Our Ref CRTR-PLAN-2019-26740

**Proposal: Amendments: Reduction from 250 to 192 berths, reduction in size of marina basin, amended facilities building and additional supporting reports and plans.**

**Location: Glebe Farm, Boddington Road, Claydon, Banbury**

**Waterway: Oxford Canal**

Fig 7.12.

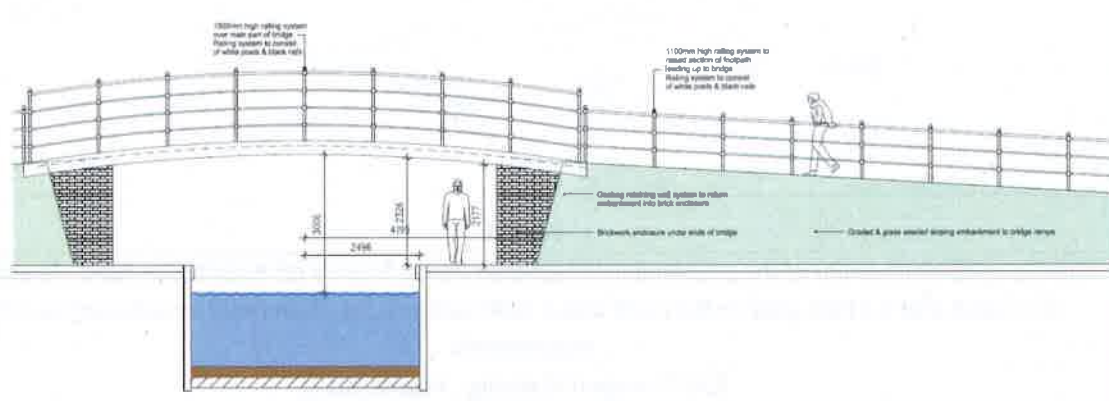
The submitted towpath bridge plan shows that the design of the proposed handrail has been amended and the upstands on the balusters have now been removed which is positive. It appears that the marina entrance has been revised slightly though the width remains the same as previously proposed. The applicant/developer has been advised that the size of the marina entrance should reflect the canal on which the marina is situated, in this case this is the Oxford Canal, which is a narrow canal.

Therefore, as per our previous response, some amendments may still be required to the marina entrance and towpath bridge to reflect the existing character of the canal. The Trust consider that the final design of the marina entrance and towpath bridge, including details on maintenance / management, could be required by condition.
